MEMORANDUM

SUBJECT: Gardiner (BLA/SEG-06-61)

DESCRIPTION: Boundary Line Adjustment in Ag-20 Zone

PARCEL
NUMBER(s): 17-18-05040-0023

GARDINIER PROPERTY

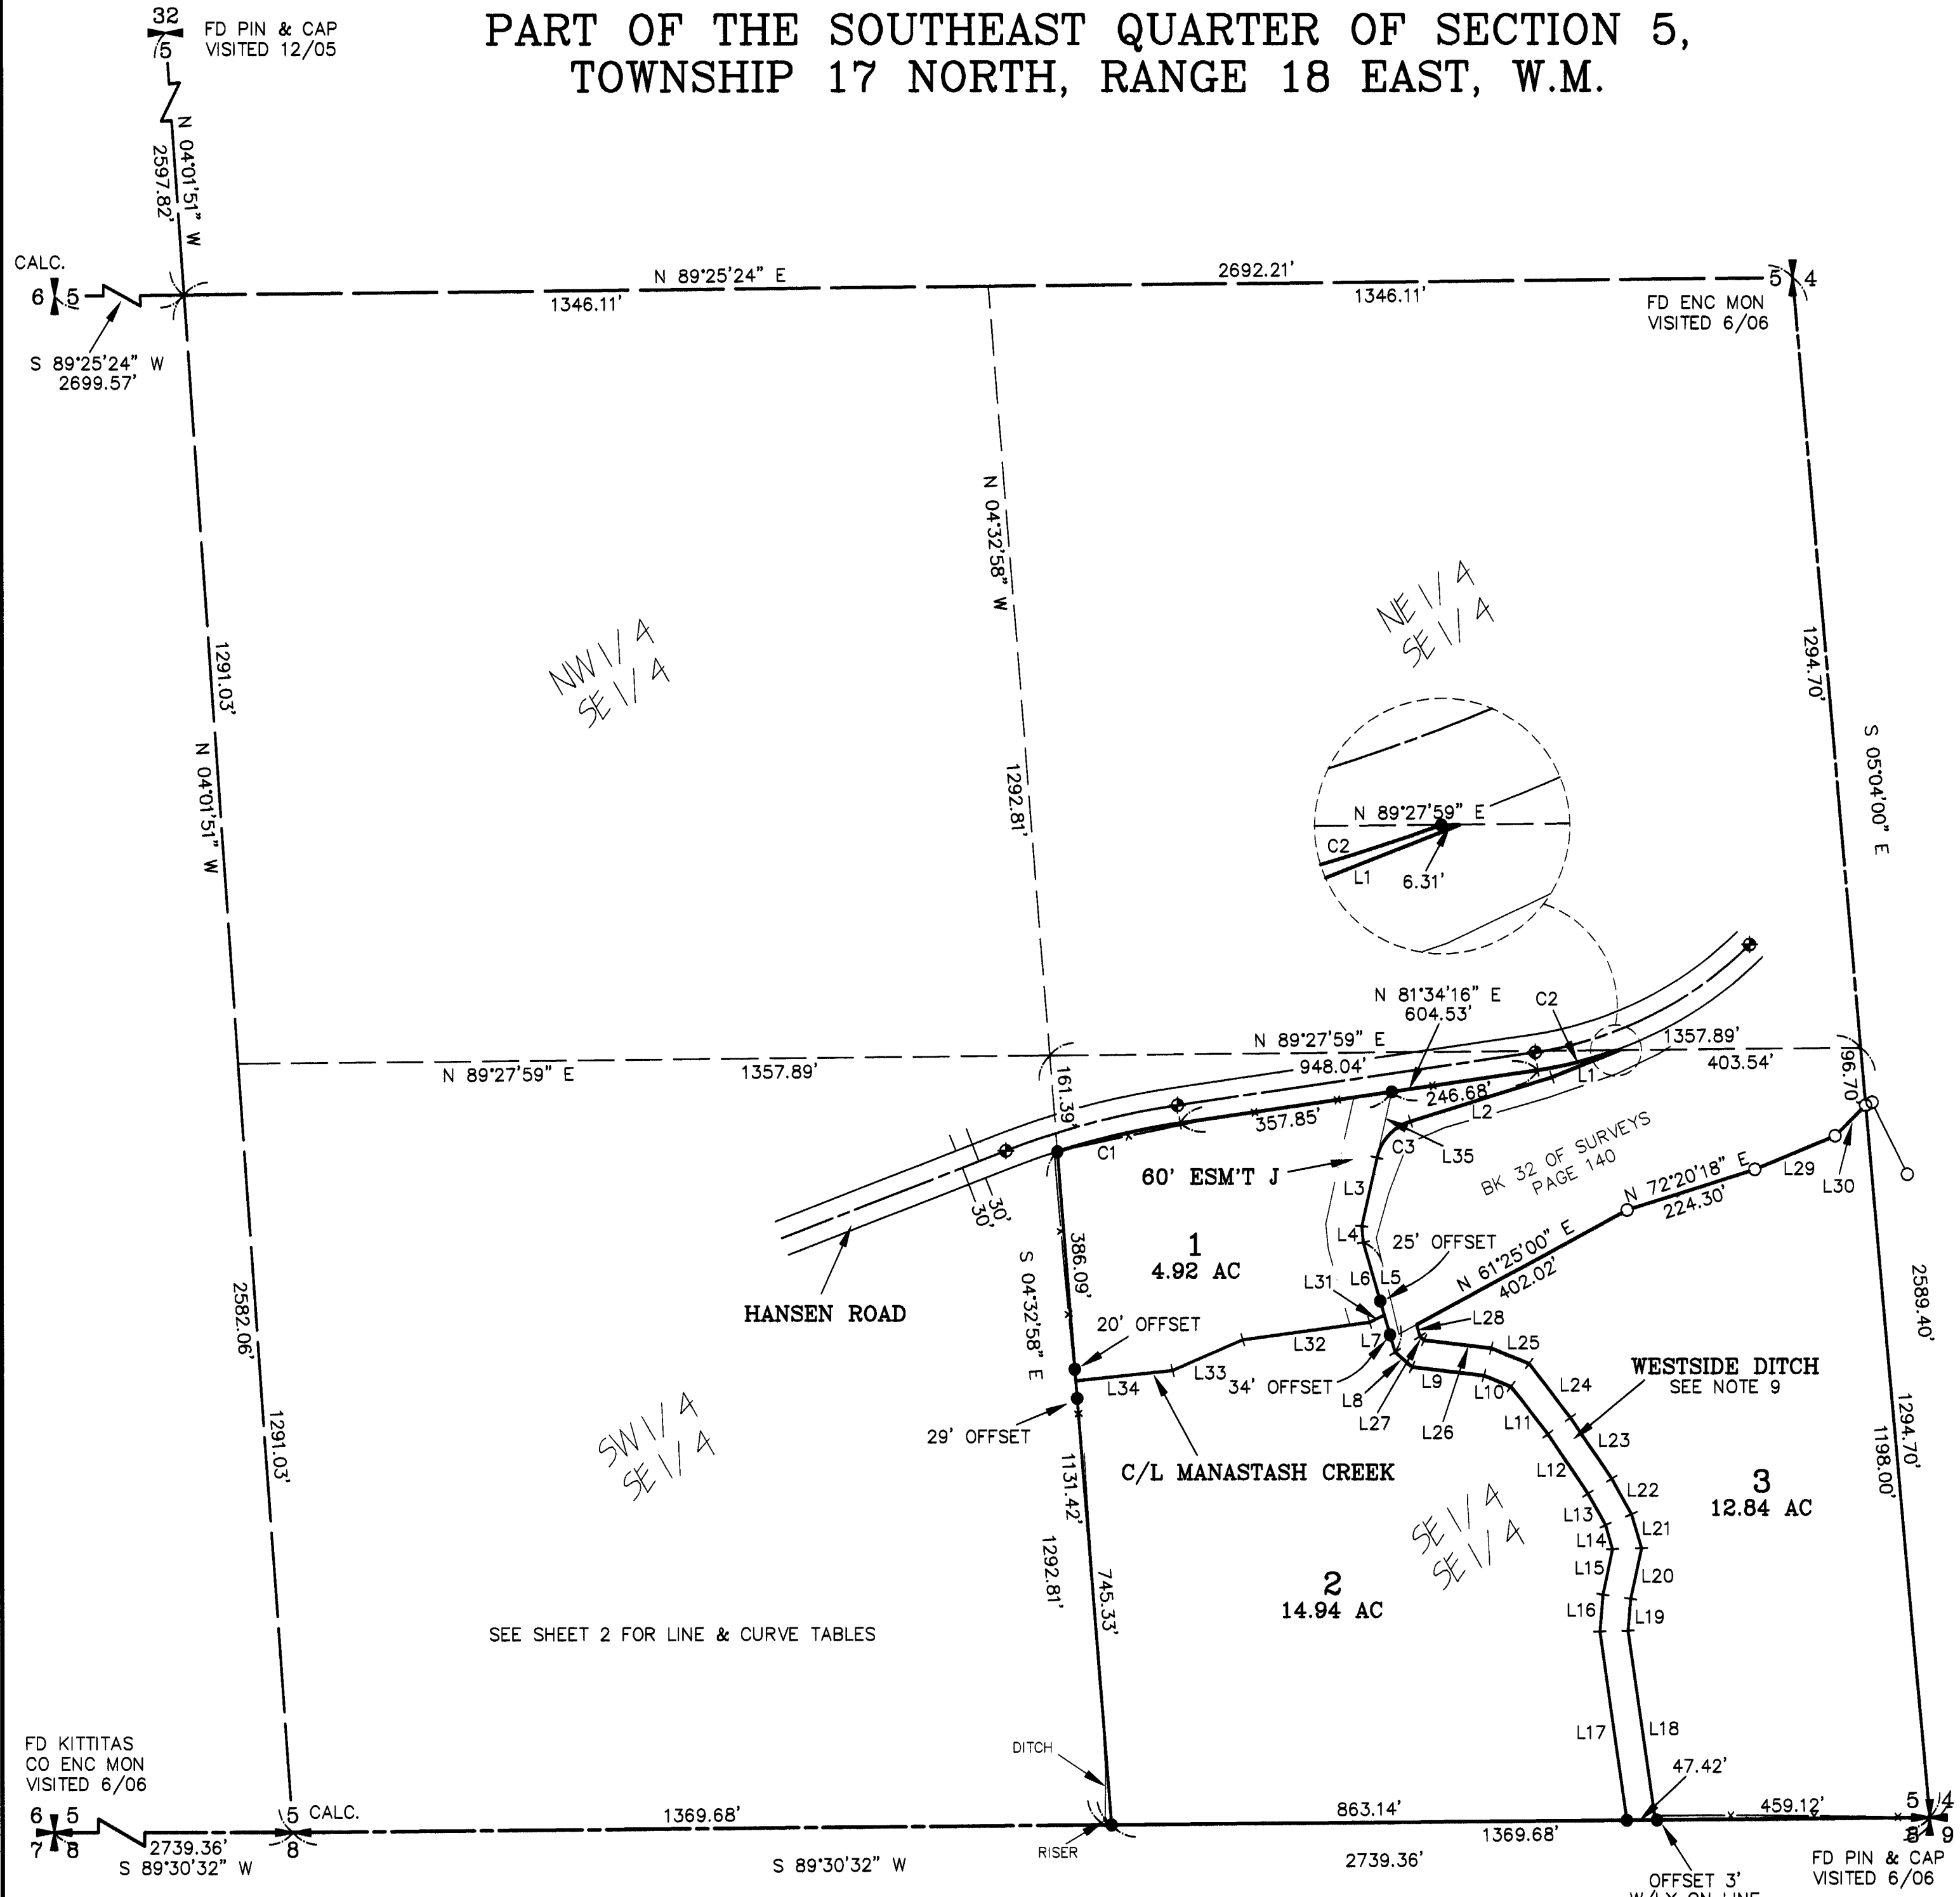
1. Prior to Final Approval the proposed access with appropriate easement(s) shall be shown and shall conform to applicable Kittitas County Road Standards.

- e. Evidence of existing access and/or evidence of access to be created should be confirmed prior to sale of property.
- f. It appears that access to some of the lots created thru this Boundary Line Adjustment and Parcel Segregation involve irrigation crossings. The applicant should contact the Irrigation District regarding any additional requirements they may have.
